From: Richard Temple
Sent: 25 January 2018 14:16
To: Planning.Responses
Subject: FW: Planning 15 Kingsmead, Felpham FP/297/17/HH

Ref FP/297/17/HH

I am writing to object to the retention of the construction of my neighbours 'summerhouse' in the grounds of 15 Kingsmead, Felpham.

DRAWING TITLE
**SUMMERHOUSE
FLOOR PLAN / SITE PLAN**

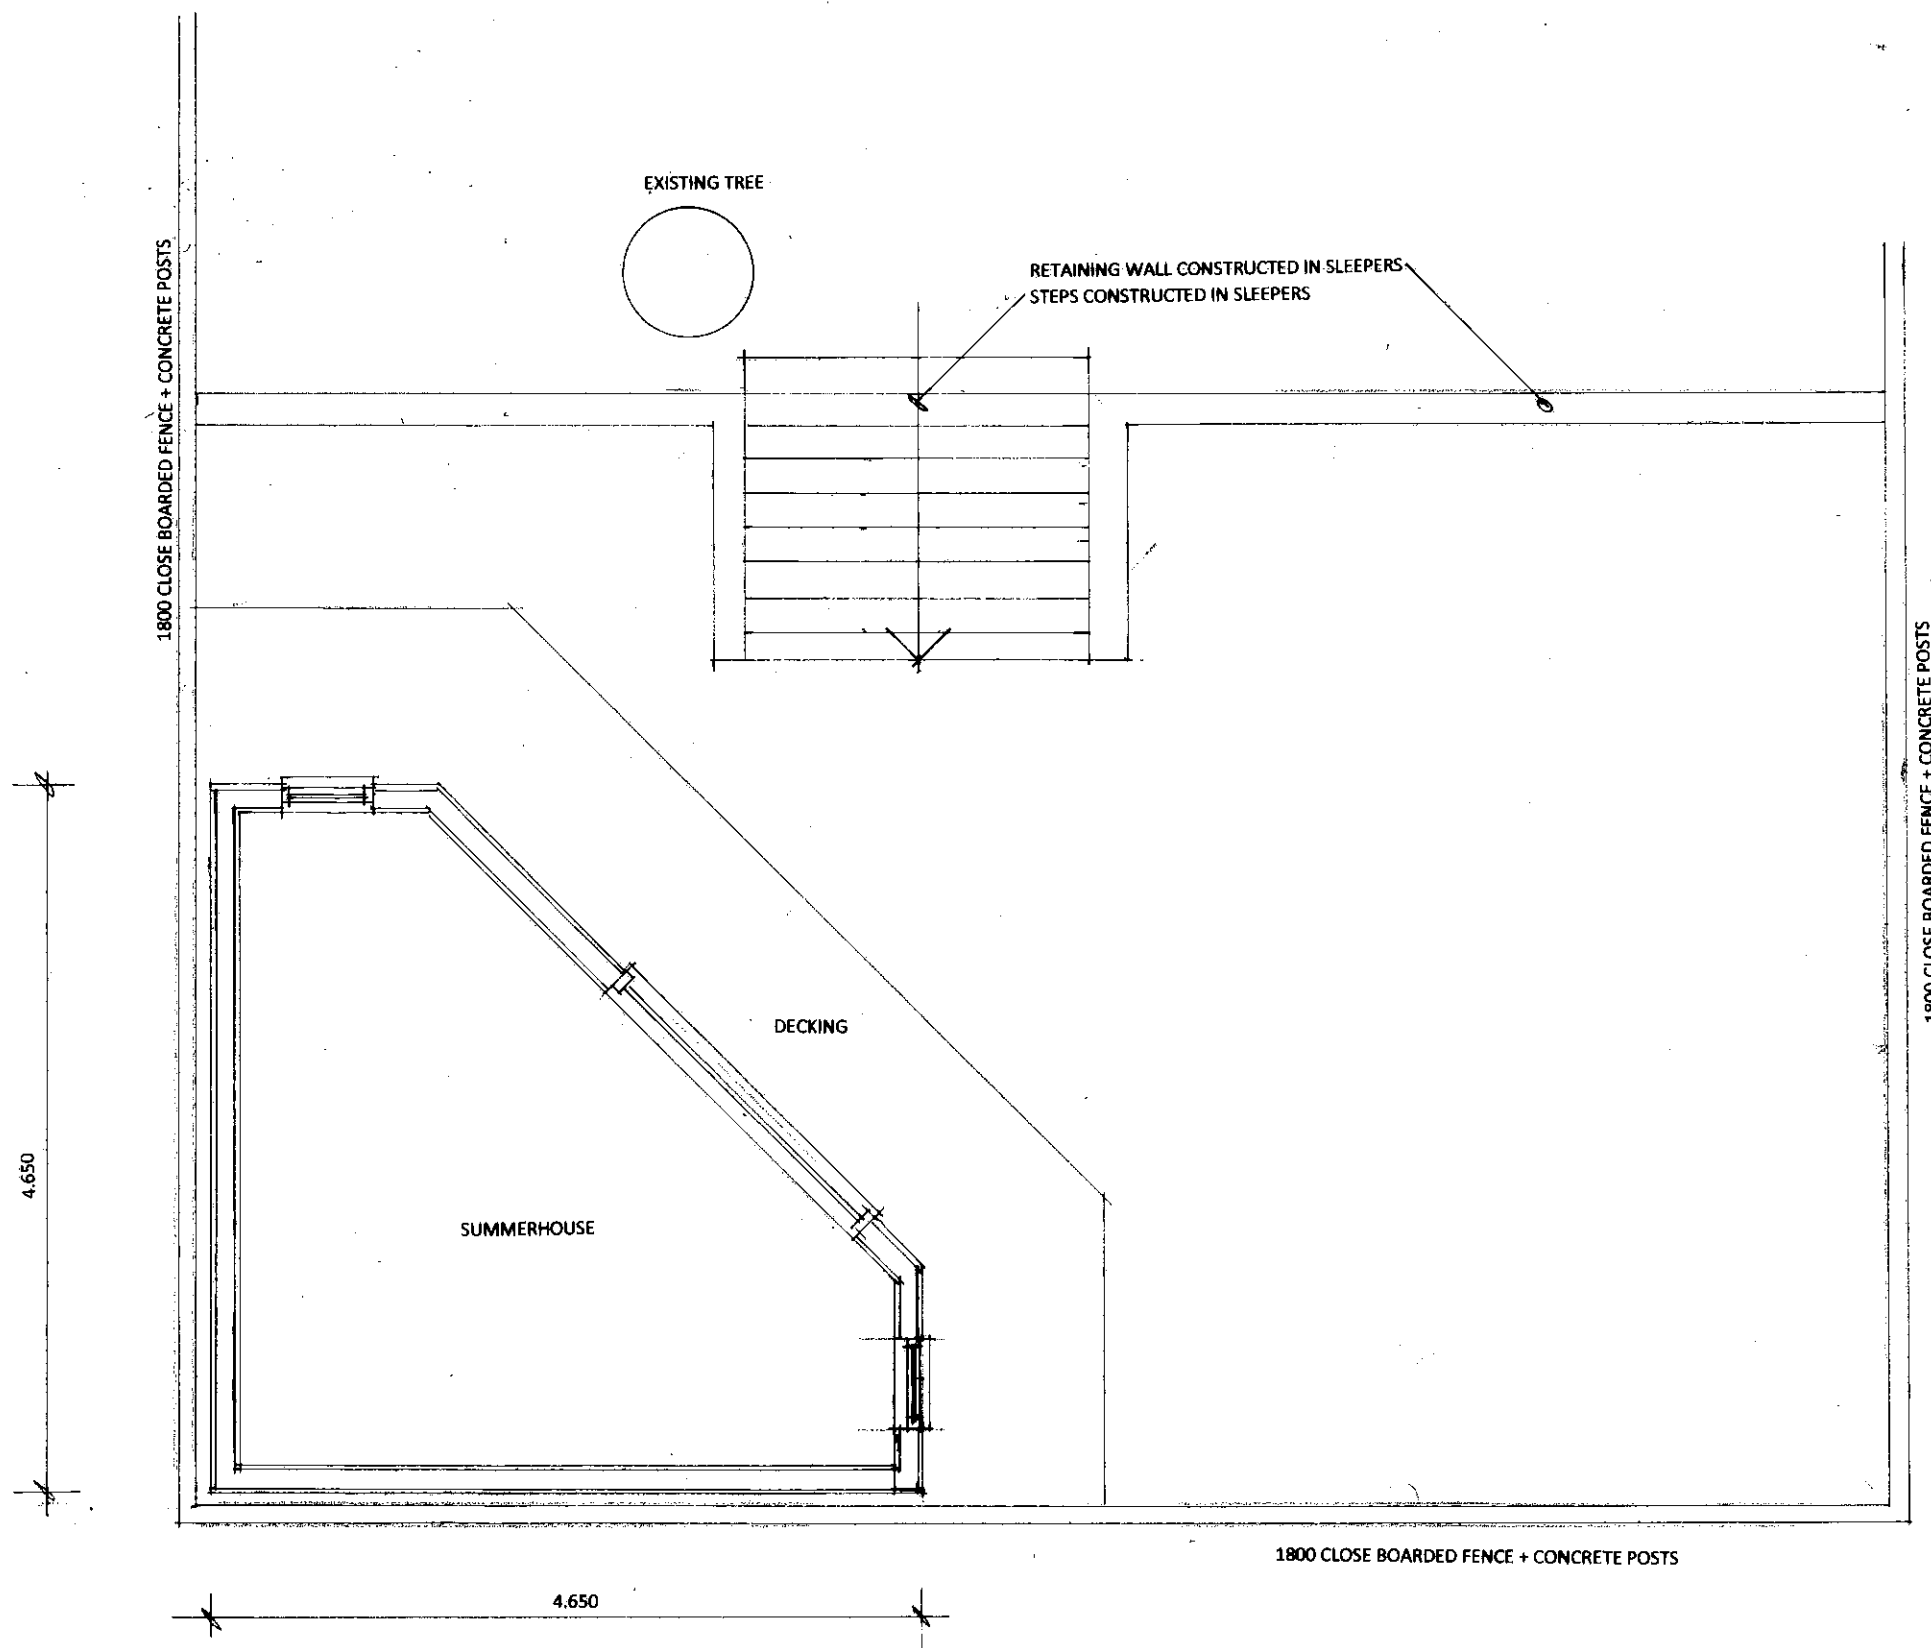
The construction is right to the edge of the property boundary and is a good 3 meters high, it towers over a 2 meter fence, so being on the sea defence it must be 4 meters high from ground level.

It invades the privacy of our garden, upstairs bedrooms and kitchen as the bi folding doors are facing in the direction of our house. It also invades the privacy of our neighbouring properties.

CLIENT
C EVANS
PROJECT
15 KINGSMEAD, FELPHAM BOGNOR REGIS, PO22 7BD
DRAWING TITLE
SUMMERHOUSE EAST ELEVATION AND CROSS SECTION
SCALE
1/50 at A3
REFERENCE
11621.17

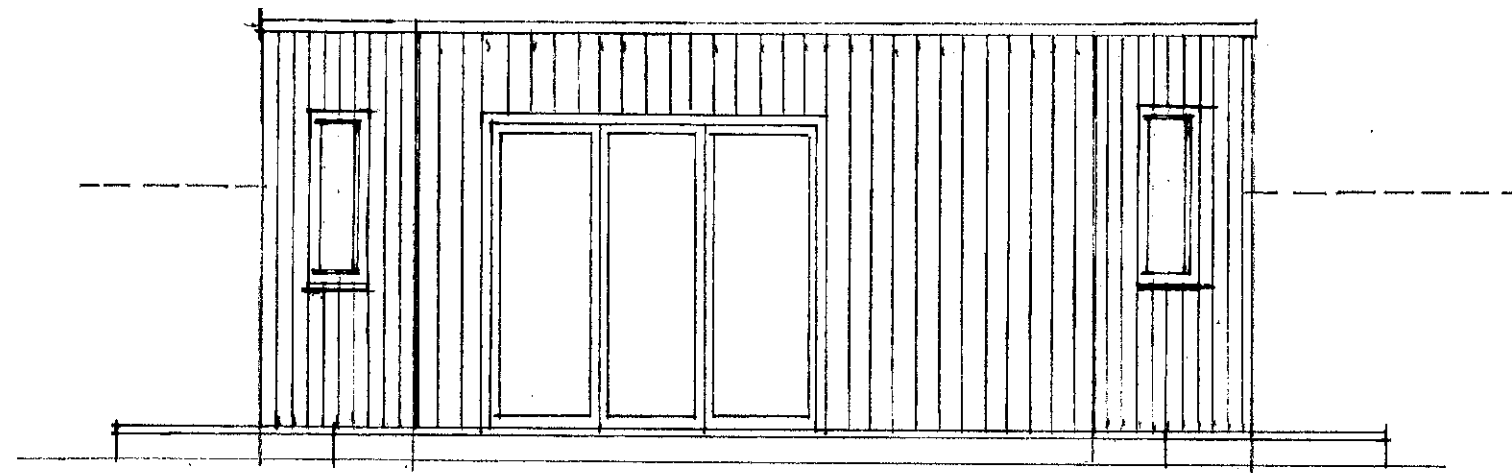
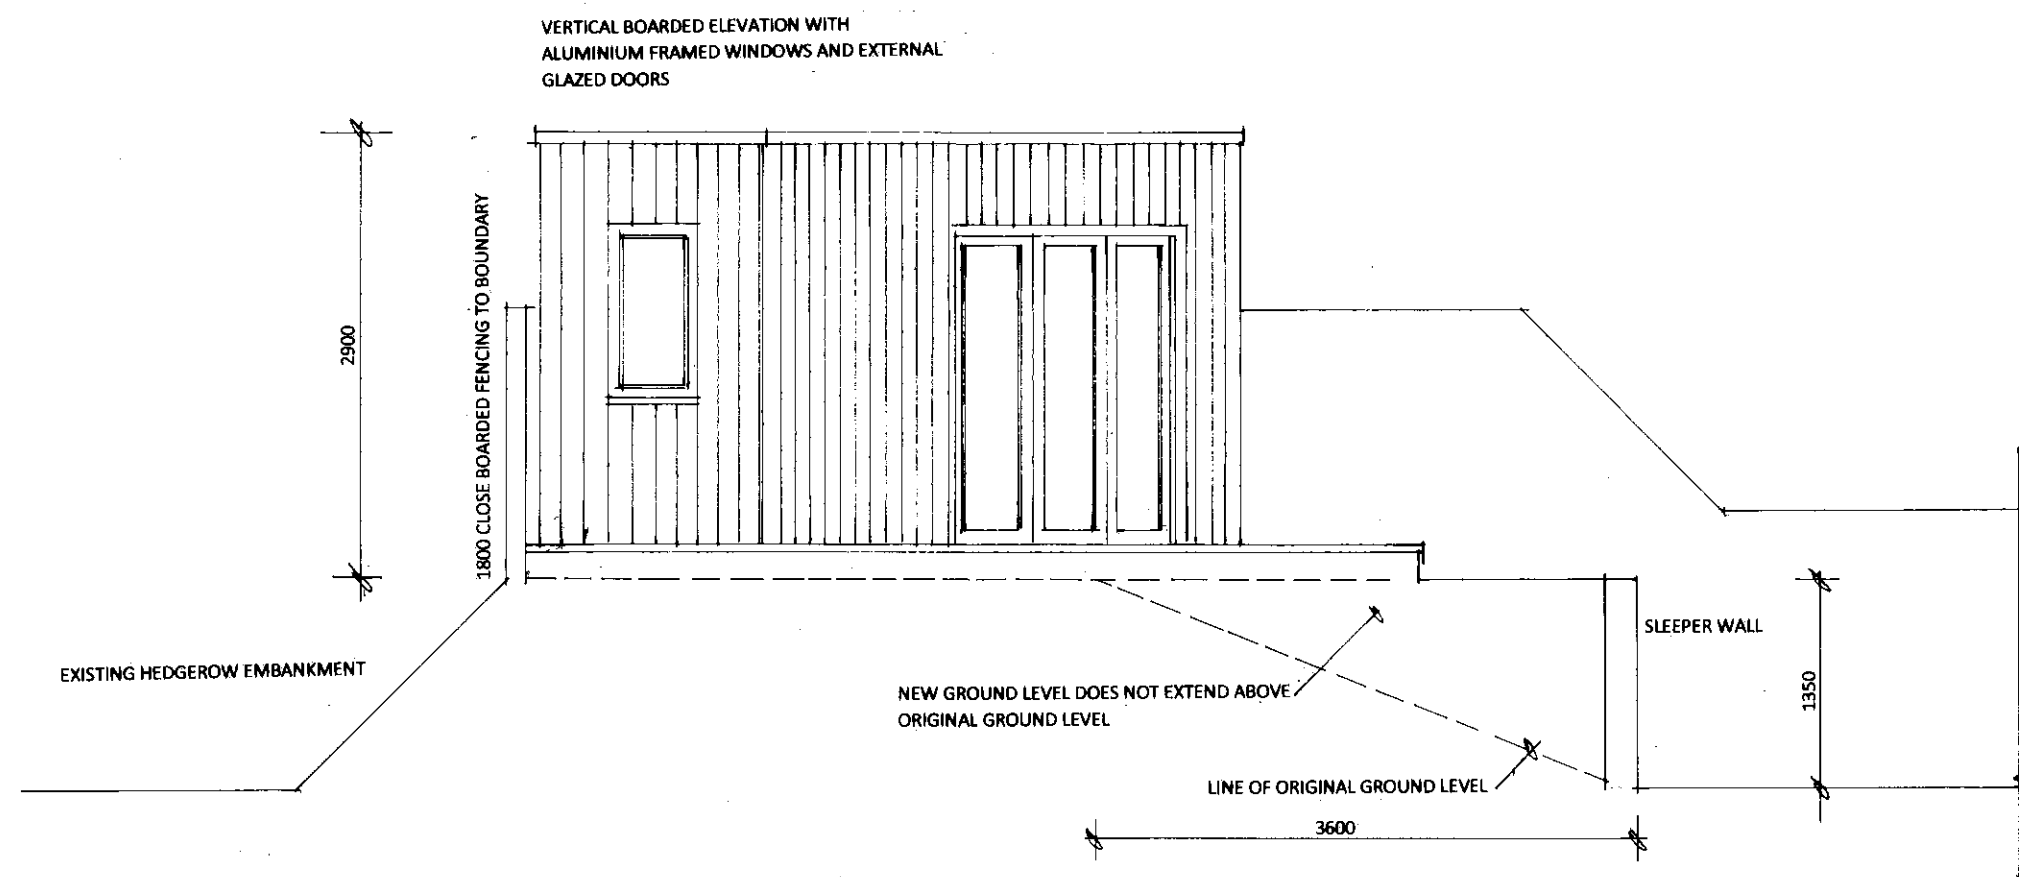
This construction has been built on top of a sea defence upon which it has been lowered by at least 23" without consent from the appropriate agencies.
